Date: 4/3/2024
Your Ref:
Previous application ref: 19/03503/FUL

Revisions to approved design and related conditions. Erection of 2 dwellings, Land at Crown Inn The Street Cerney Wick South Cerney Gloucestershire GL7 5QH Application Reference Number: 19/03503/FUL

Condition 2 - alterations to the garage roofs, parking and fenestration dormer style to both plots:

DRAWING No:- 1020 / CAM/2023 / 7  
DATE :- MAR. 2024 REV: A  
SCALES :- LOCATION: 1:1250  
BLOCK PLANS 1:500 & 1:250

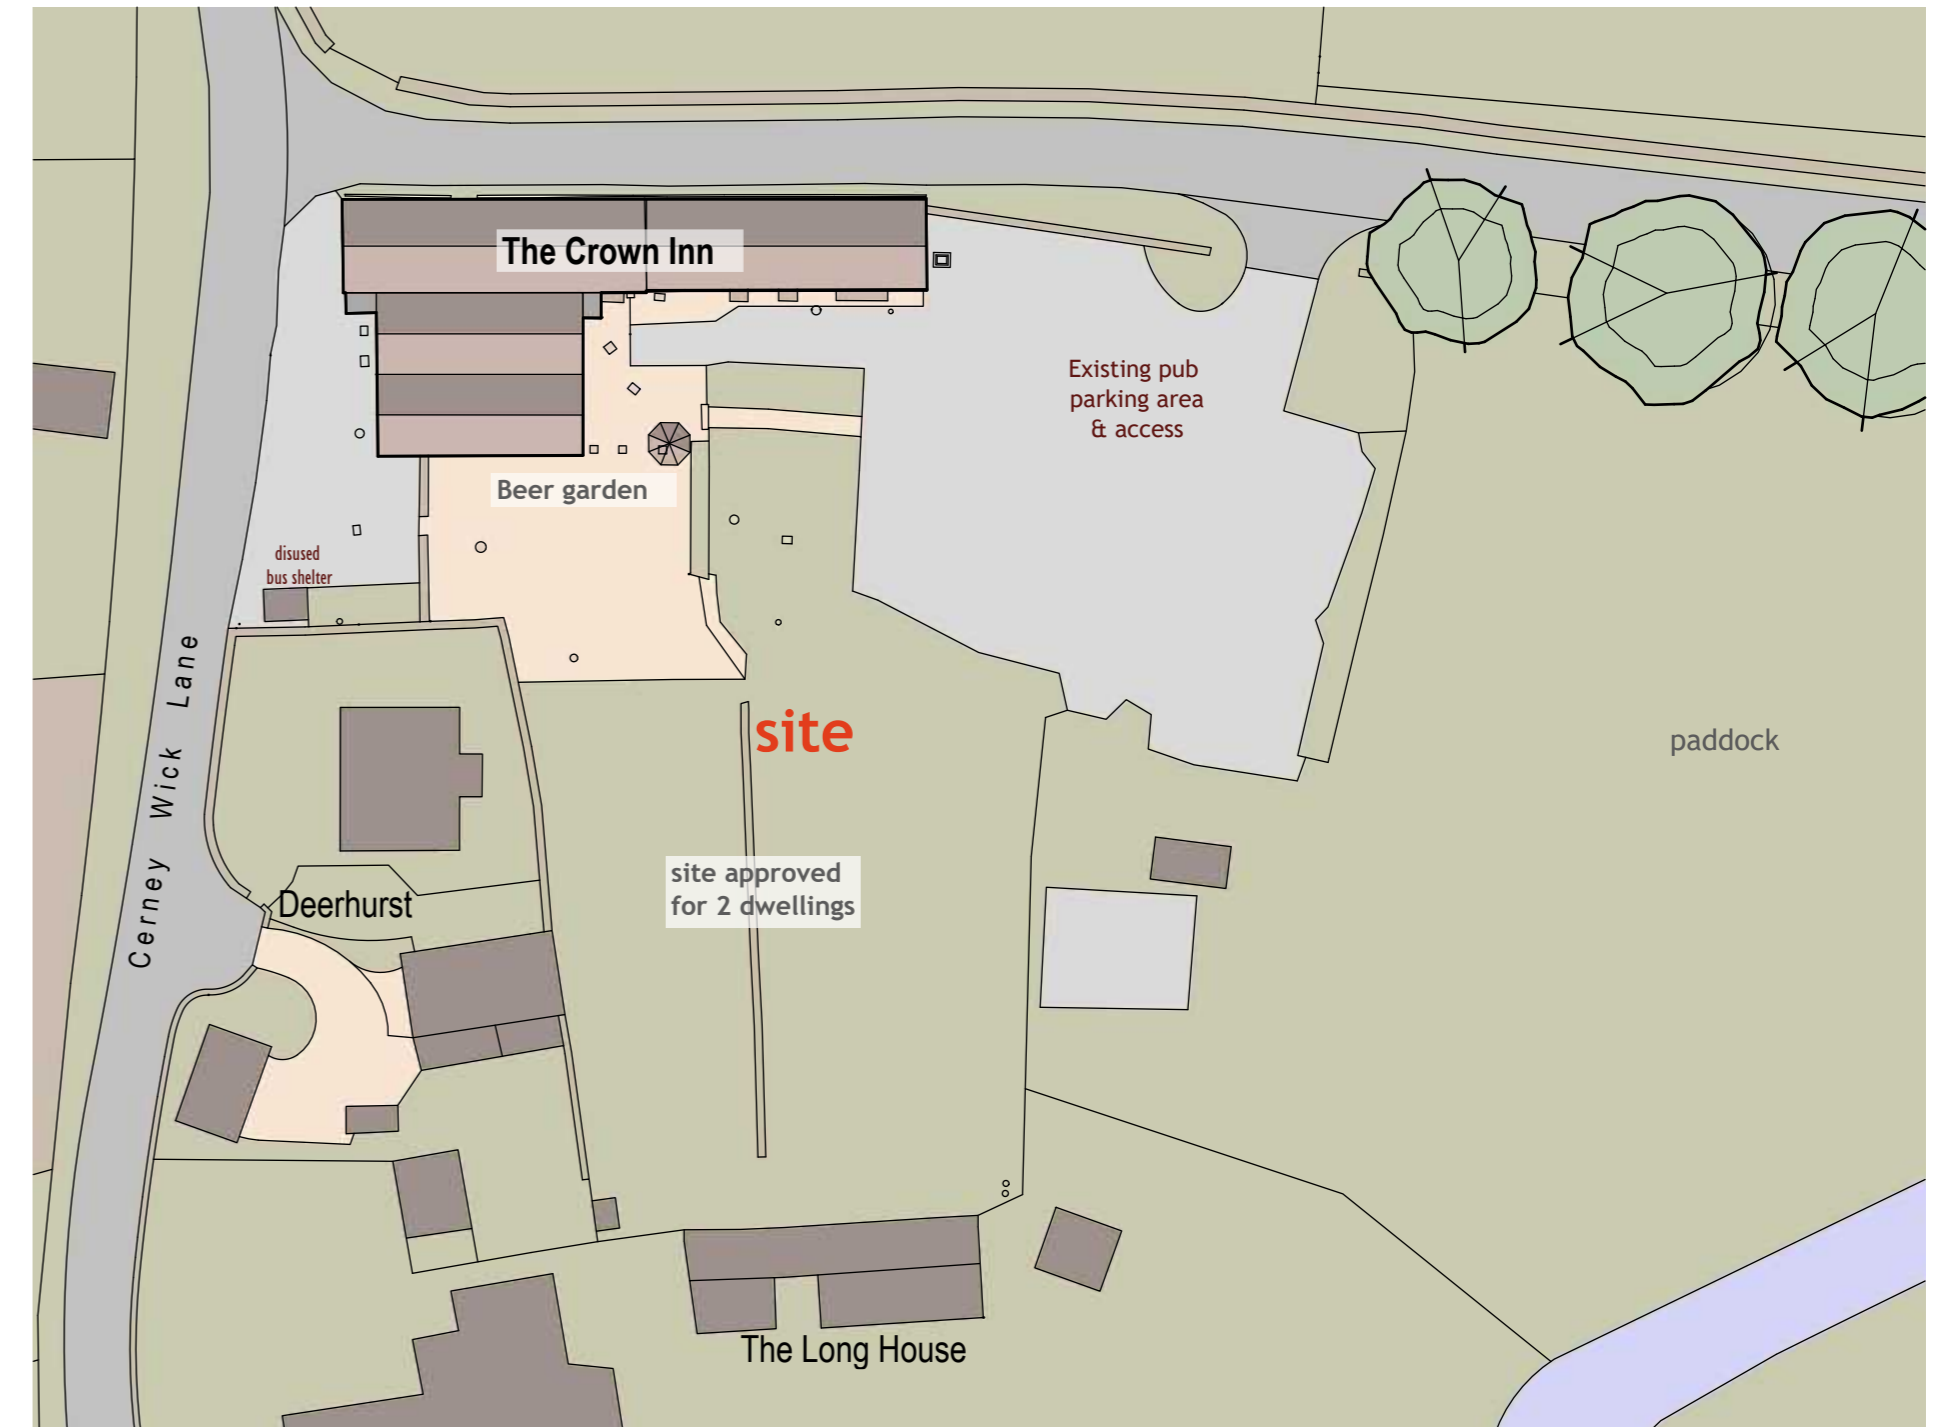
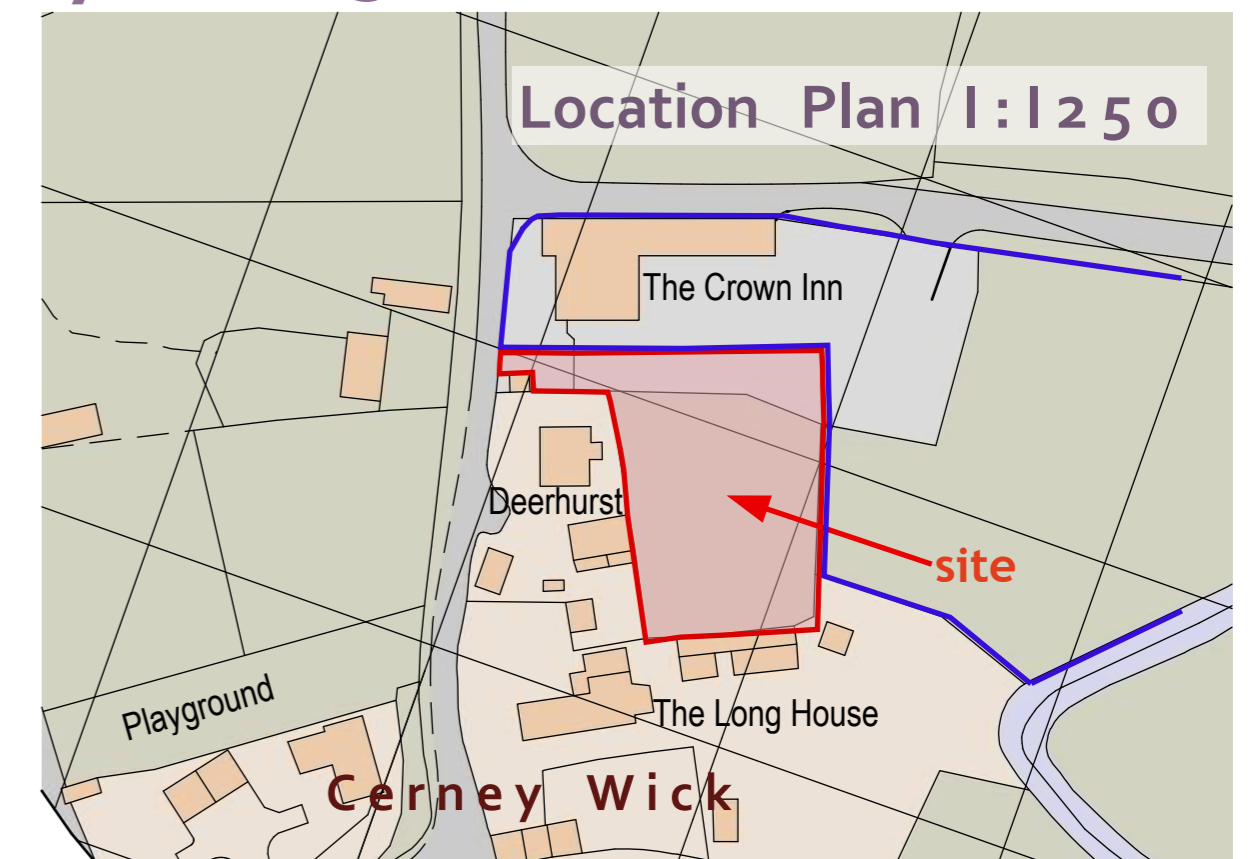
- 3) PROPOSED SITE PLAN AS PROPOSED: The access to remain as approved, the proposed parking areas amended as shown on the attached revised plans. Plot 1 to have one space in front of the garage and one in front of the house. Plot 2 to retain the same arrangement as approved but moved further back (south). A 2 metre high wall to divide the plots from the Pub is proposed in a revised position to allow slightly more distance to pub that can be landscaped, Wall to be stone faced north side rendered to south or plot side.

**PROJECT:** REVISED DWELLINGS AND ROAD ACCESS, PLOTS IN GROUNDS OF THE CROWN INN, CERNEY WICK, GLOS. GL7 5QH.  
**DRAWING No.:-** 1020/CAM/2024/9 REV DATE: JAN 2024

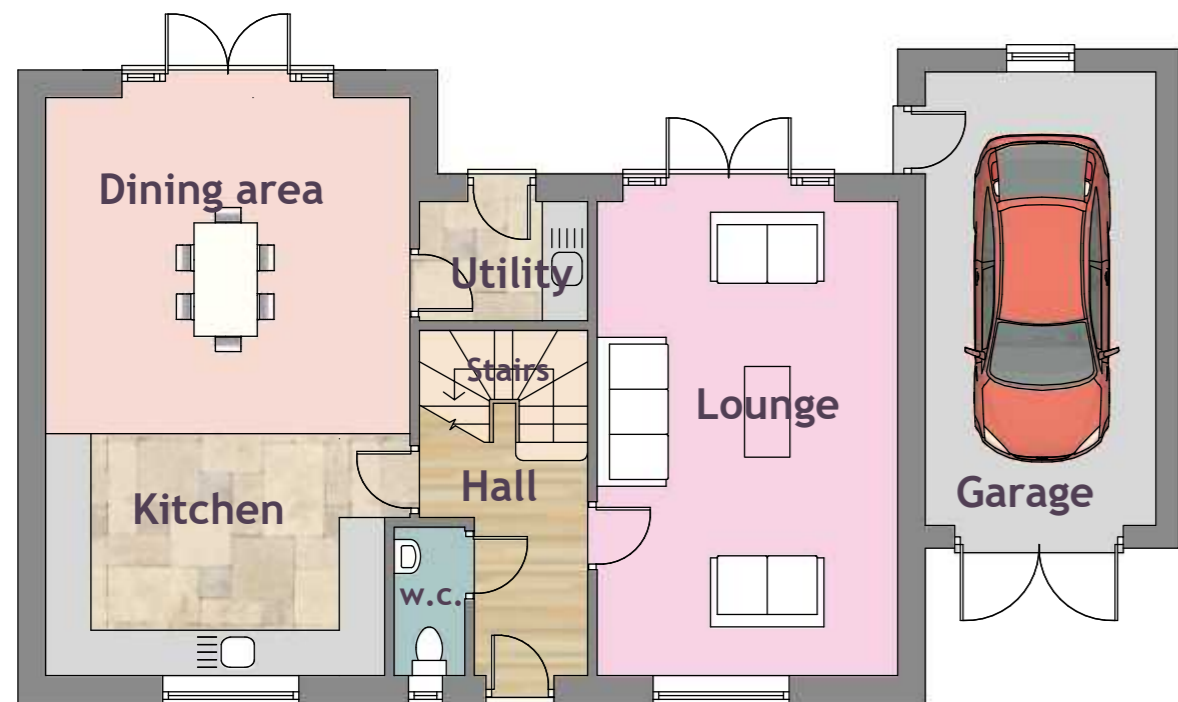
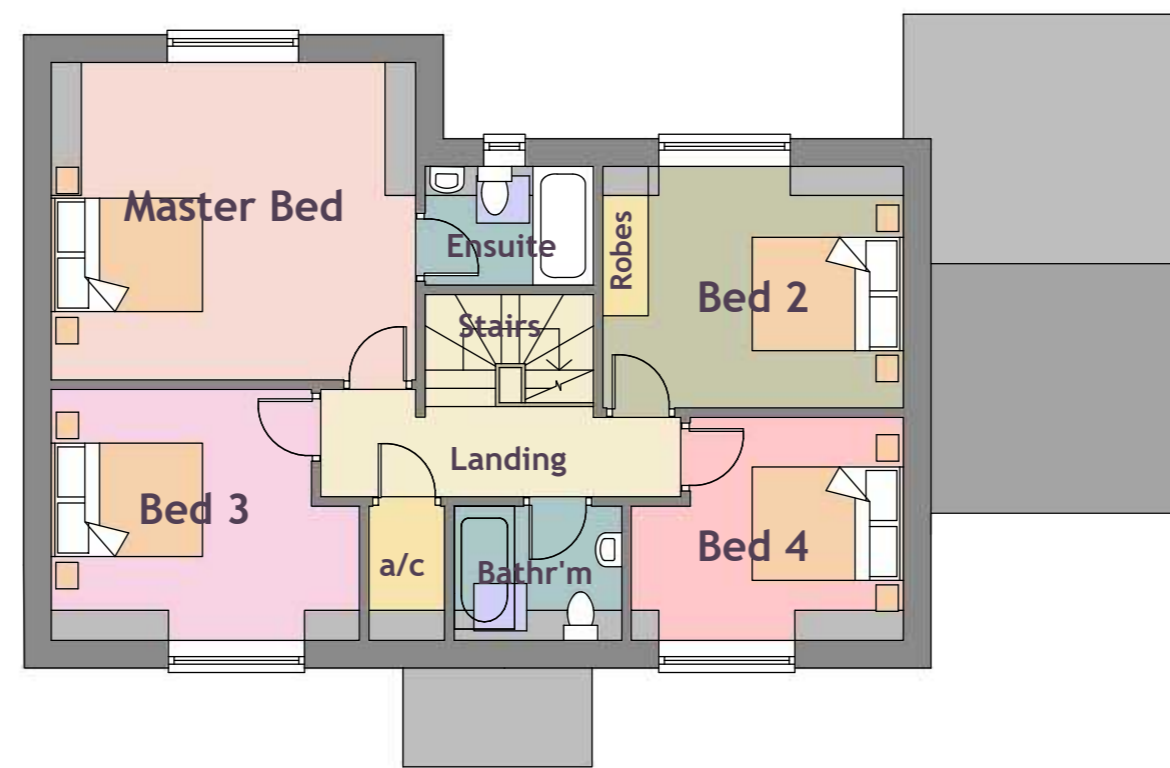
- 2) PLOT 2: The garage set back to allow for roof to intersect with the main house roof on the rear for more pleasing look. Main house frontage: gable dormer moved 300mm right for valley drainage clearance, large single dormer changed to gable dormer to mirror left side. Porch changed from large open gable to simple lean to on posts.

For the sake of clarity and correctness the approval decision condition 2 requires amending as follows: plan No. PR04-B incorrect floor plans, (they are the same as plot 1), - elevations and block plan are correct. This variation will correct the draughting error.

PROJECT: MINOR AMENDMENTS TO DWELLINGS AND PARKING AREAS
 LAND AT THE CROWN INN, CERNEY WICK, GLOS. GL7 5QH.
DRAWING No.:- 1020/CAM/2024/8 REV **DATE:** JAN 2024

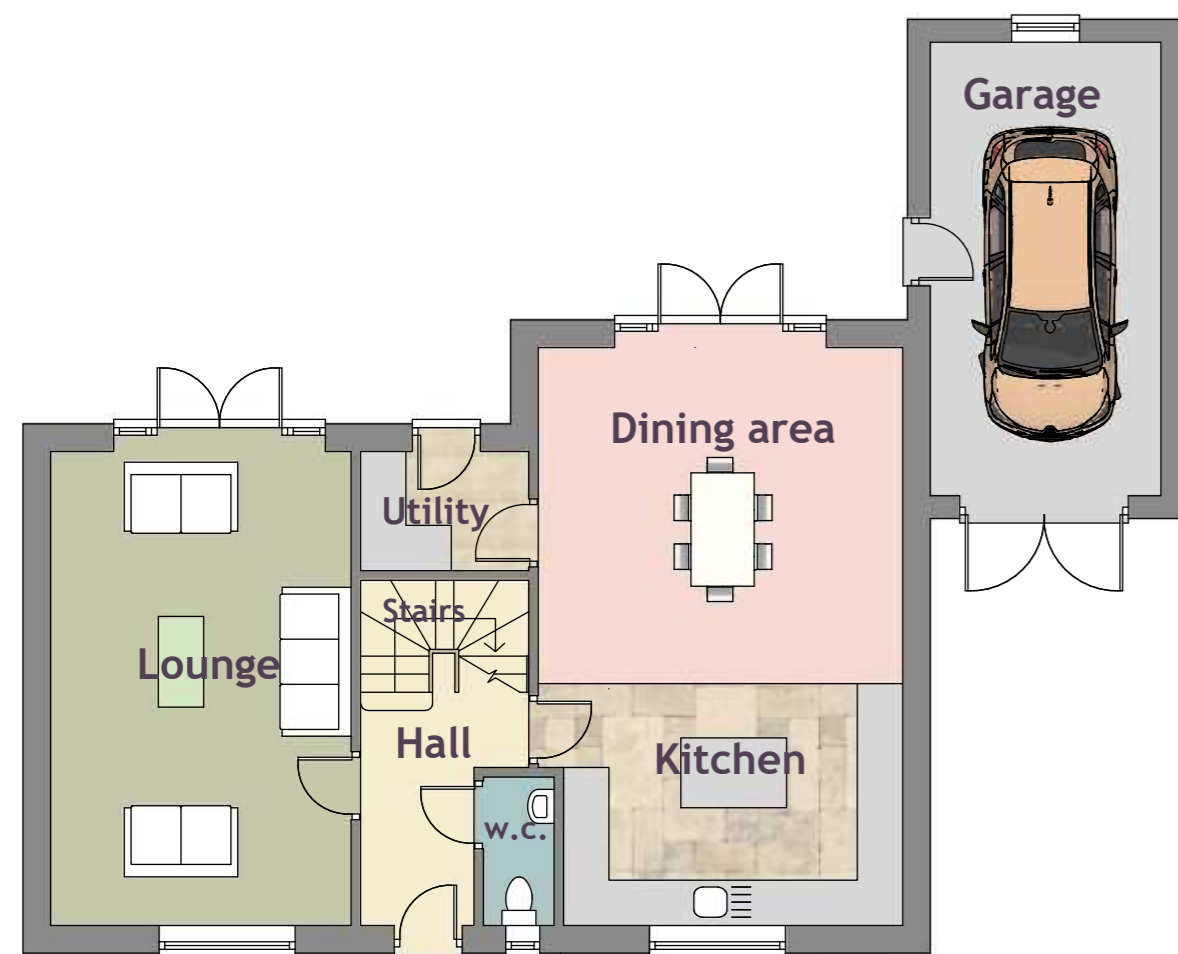
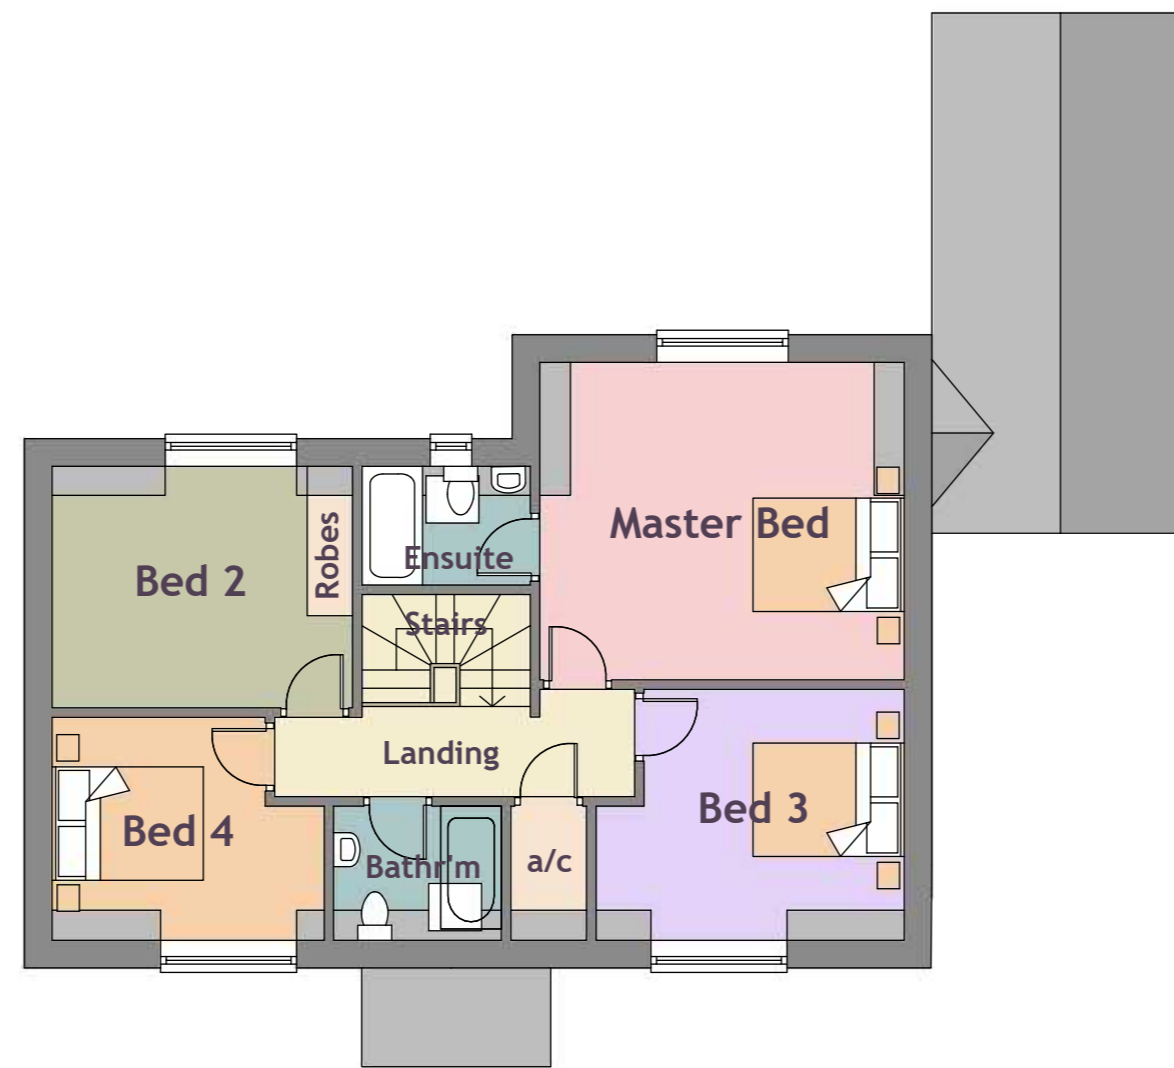
- 1) PLOT 1: The garage set back slightly with roof reduced in bulk, revised to small gable to front and rear elevations. Main house frontage: gable dormer moved 300mm right for valley drainage clearance, large*
-

single dormer changed to gable dormer to mirror left side. Porch changed from large open gable to simple lean to on posts.
